LINDFIELD LEARNING VILLAGE - RESPONSE TO SUBMISSIONS (BUILT HERITAGE)

This letter has been prepared in response to the Public Agency Comments on SSD8114 (Lindfield Learning Village). The comments provided by Ku-Ring-Gai Council and Heritage NSW relevant to built heritage are addressed in this letter. Urbis comments are provided below each agency comment.

TITLE STAGE 2 - GA PLAN -
LEVEL 4 - ZONE J

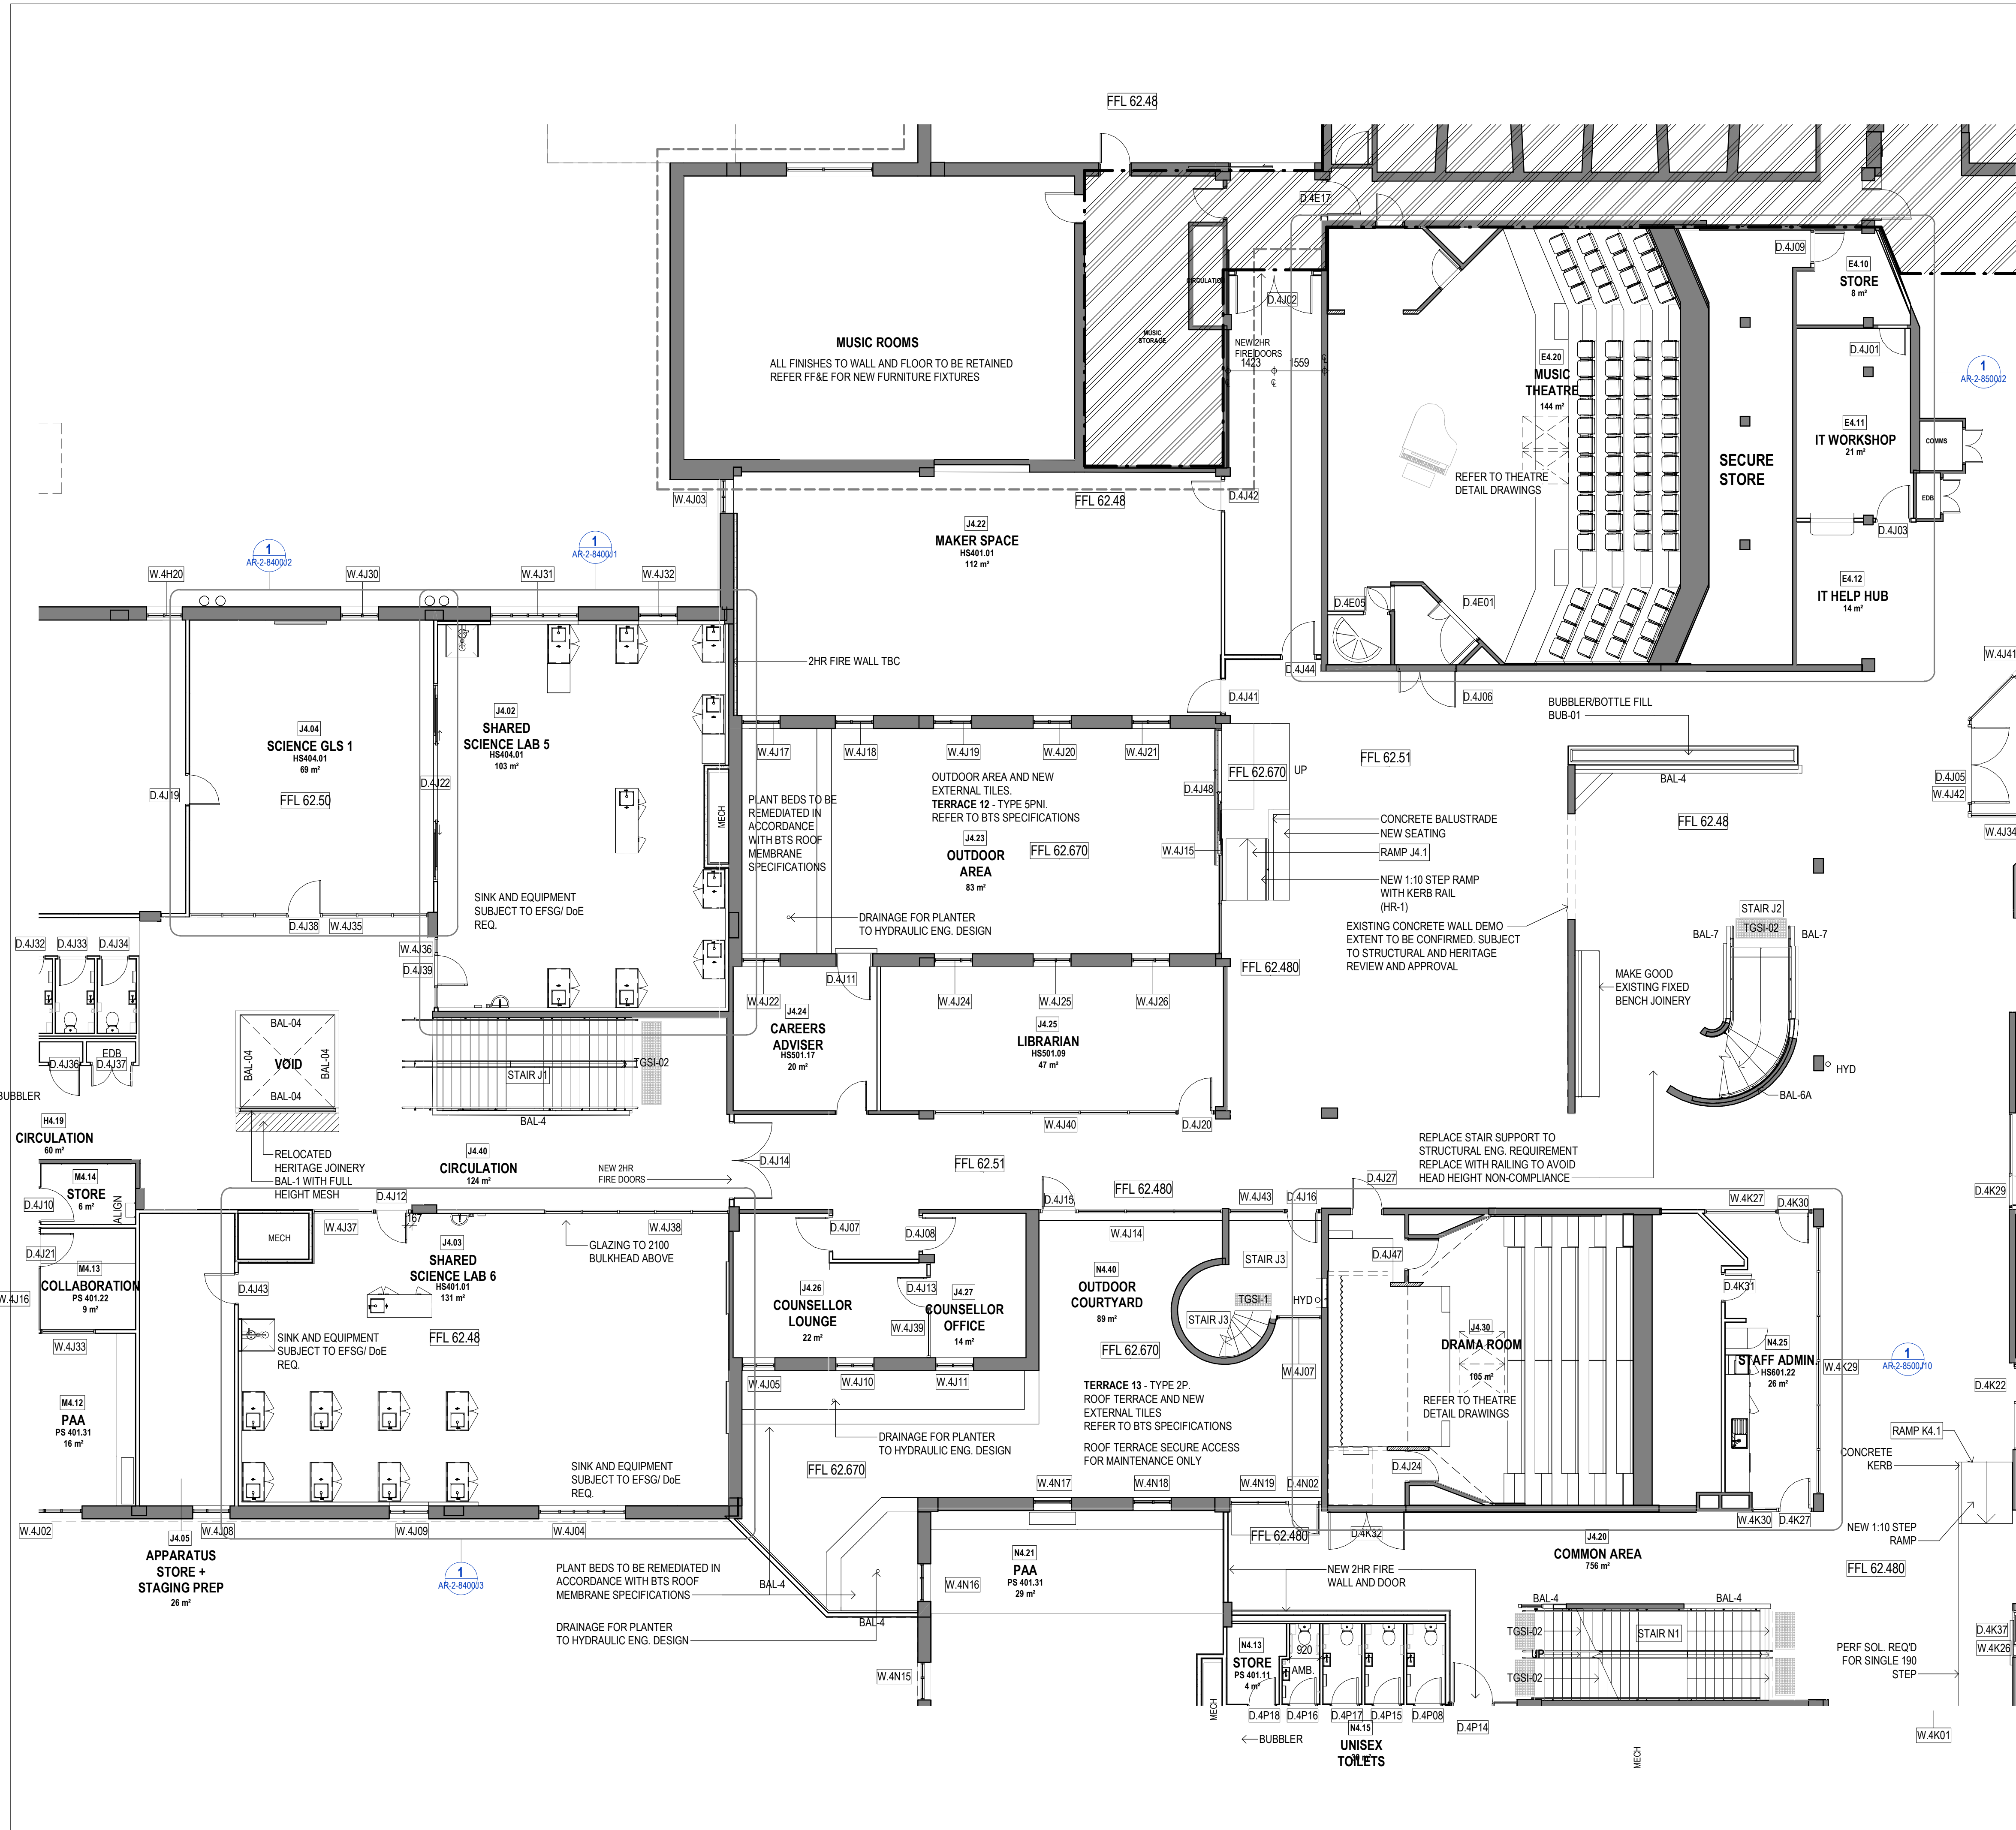
The removal of two portions of concrete wall for increased light penetration will require the removal of a substantial amount of original fabric, identified in the CMP as of high significance.

This should be avoided and the Heritage Council recommended condition of consent from the correspondence dated 13 December 2019 (above) be included requiring that an alternative light source is designed

It is not proposed to remove two portions of concrete, only a single opening is proposed per the plans provided with this response.

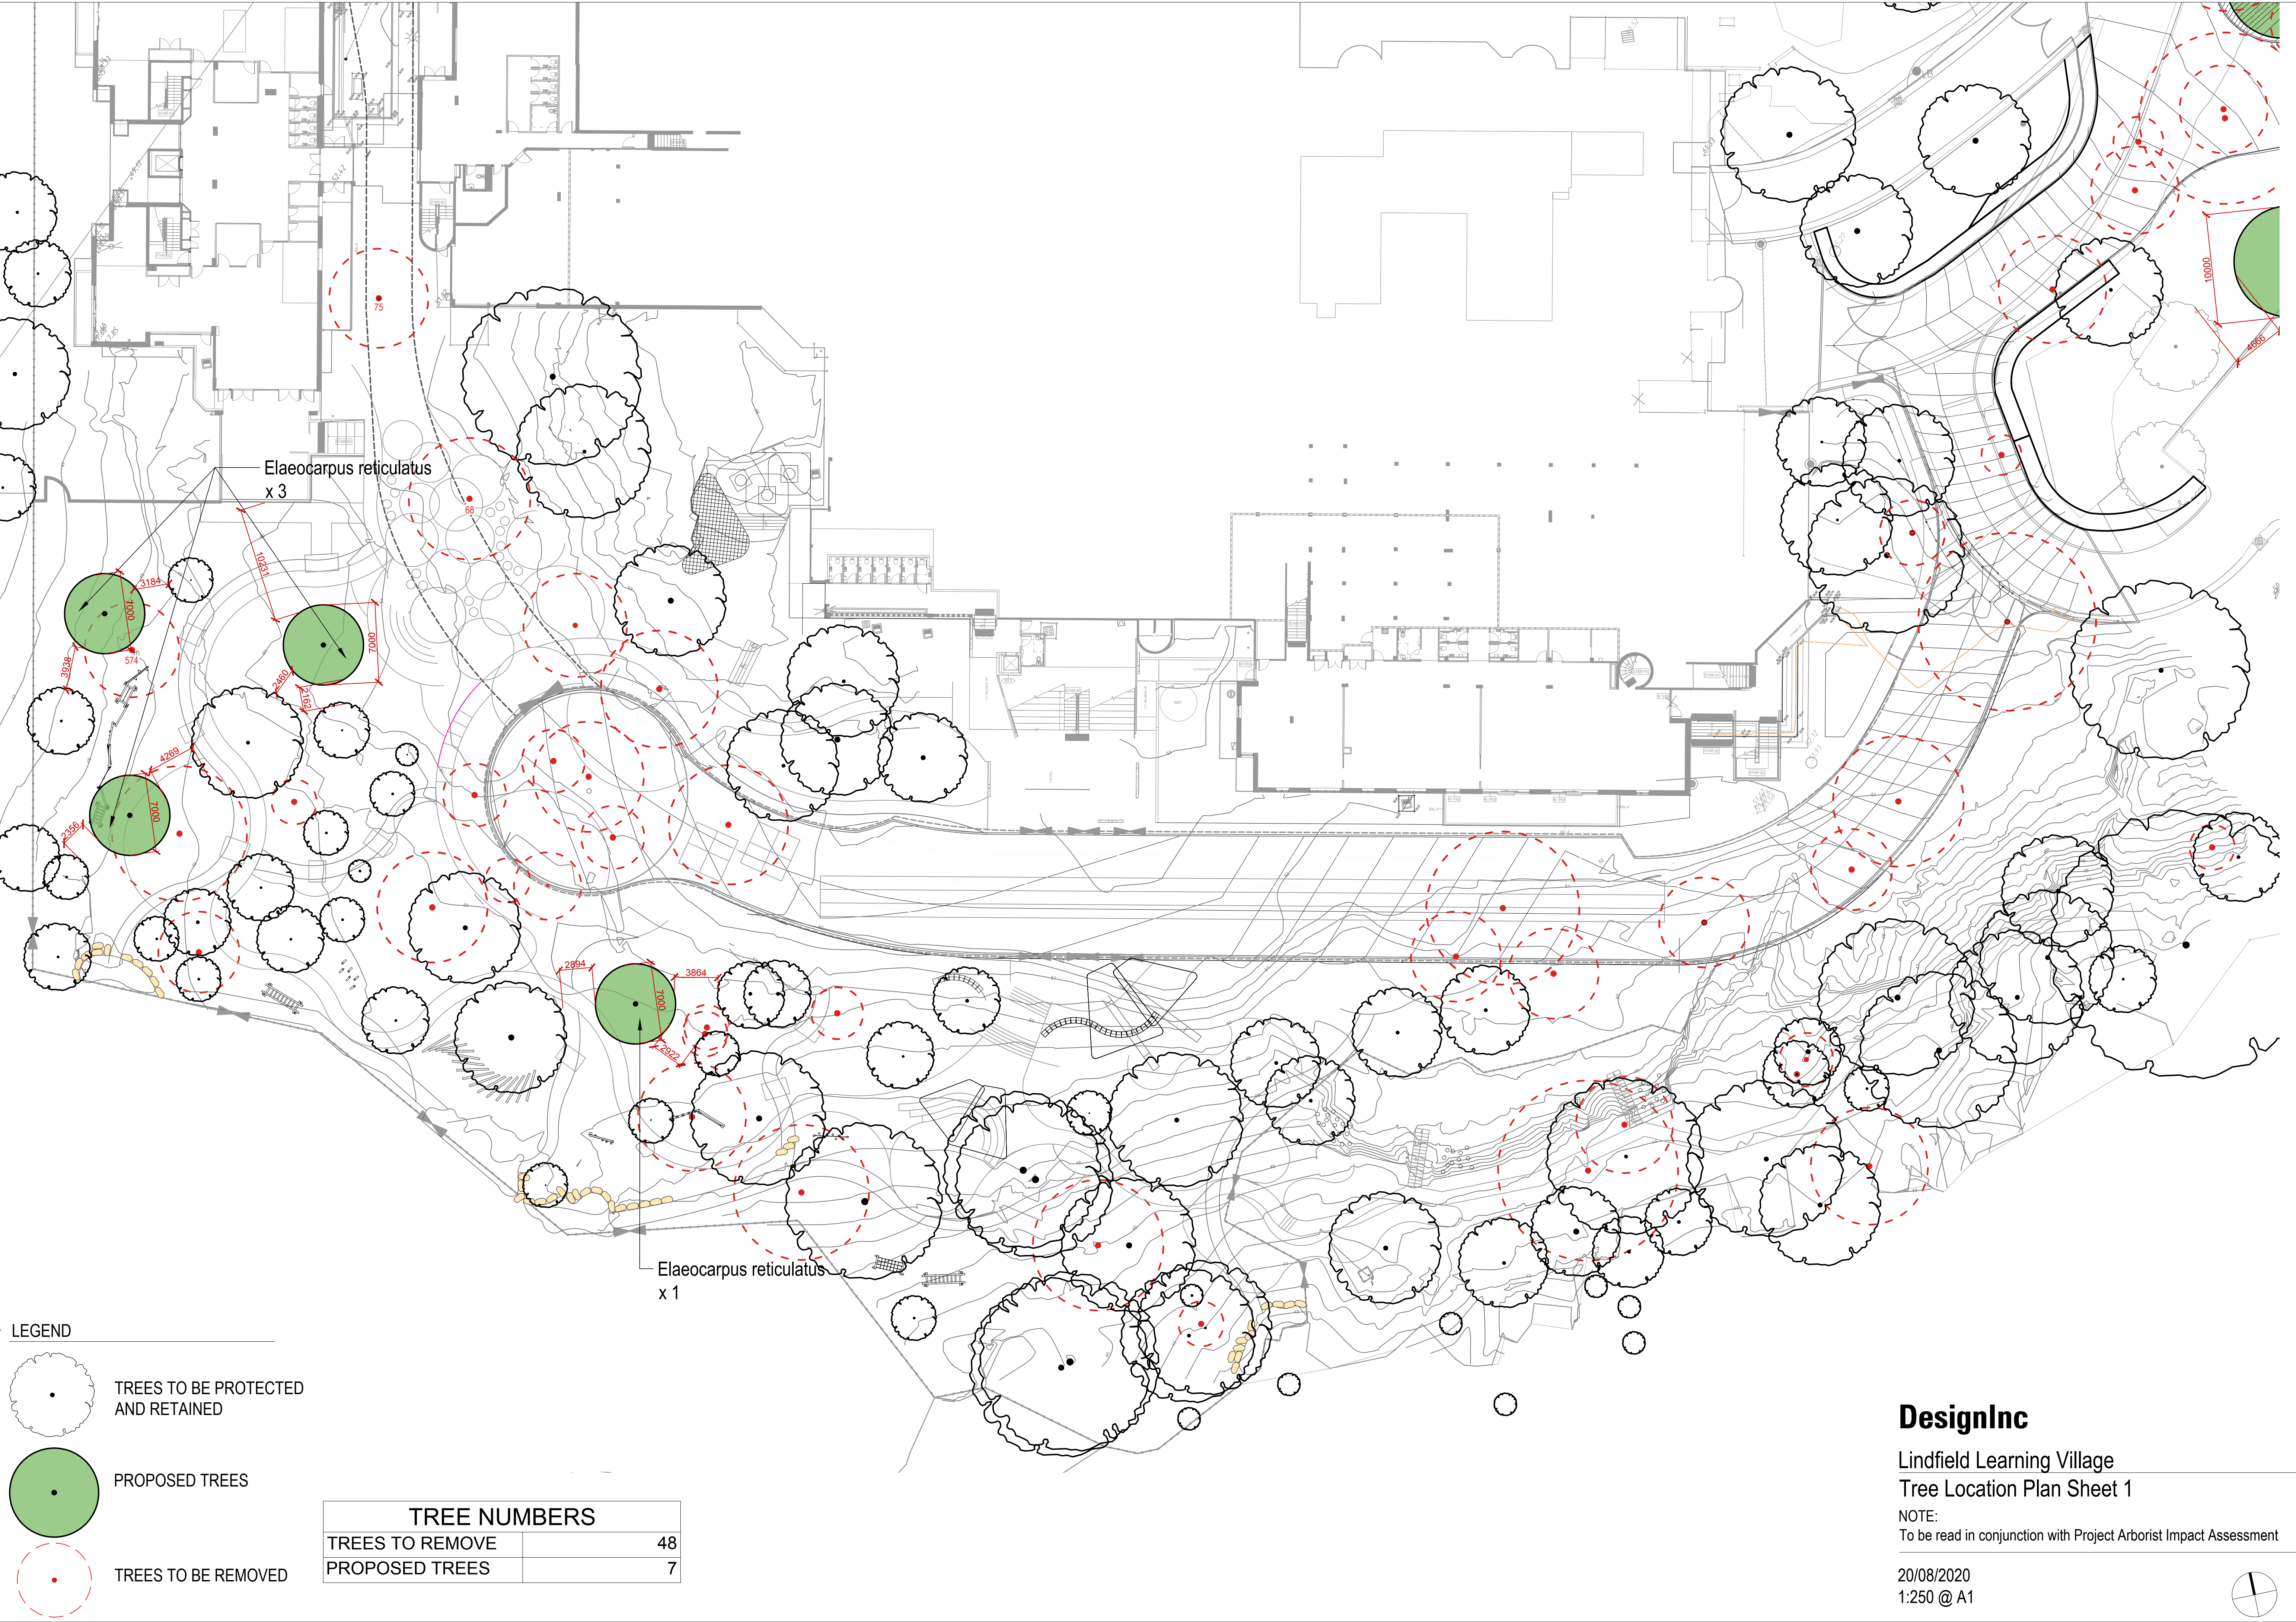
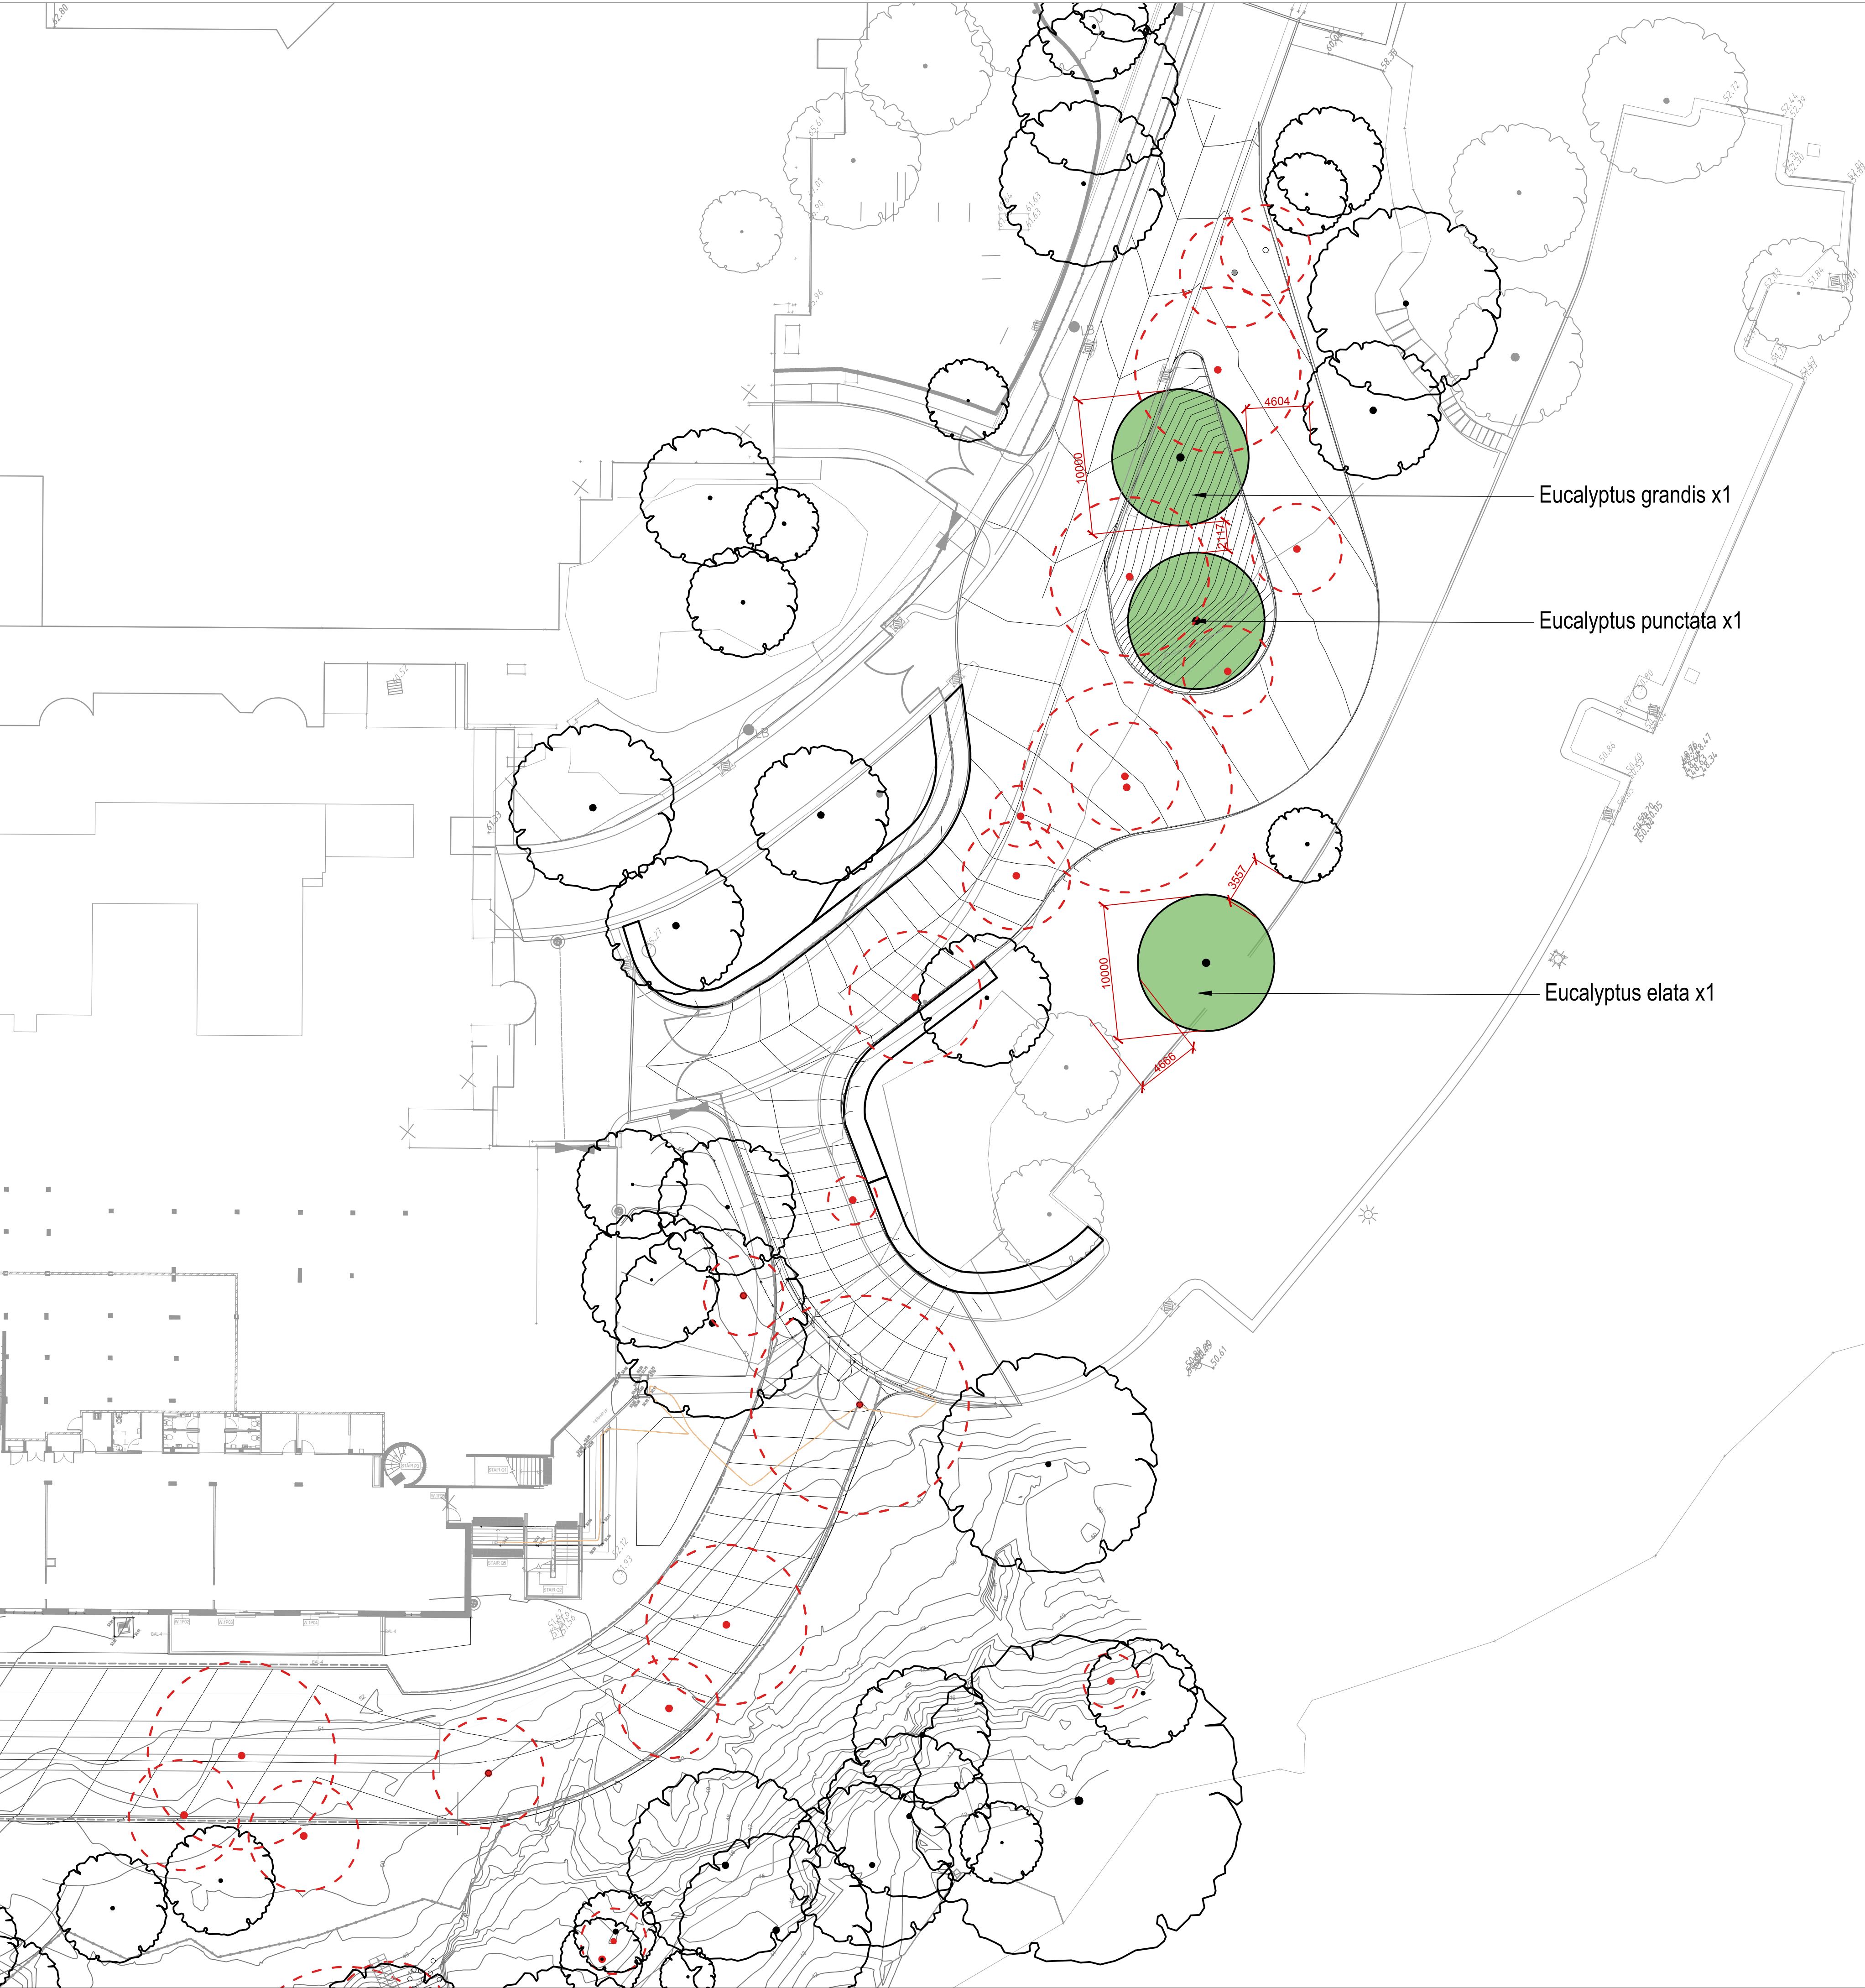
HNSW comment: Noted, however further investigation must be undertaken by the Applicant for replacement tree planting within the context of the landscape works at the site to mitigate the removal of the 26 trees associated with the Link Road, an additional 16 trees from the original proposal.

Noted. Since the previous Response to Submissions it has been found that 4 additional trees are able to be planted on the site in addition to the 3 previously identified (7 trees will be reinstated in total at this time). Notwithstanding, Urbis' previous recommendation to include the below Condition of Consent remains relevant. '

Urbis' previous recommendation to include the below Condition of Consent remains relevant. '
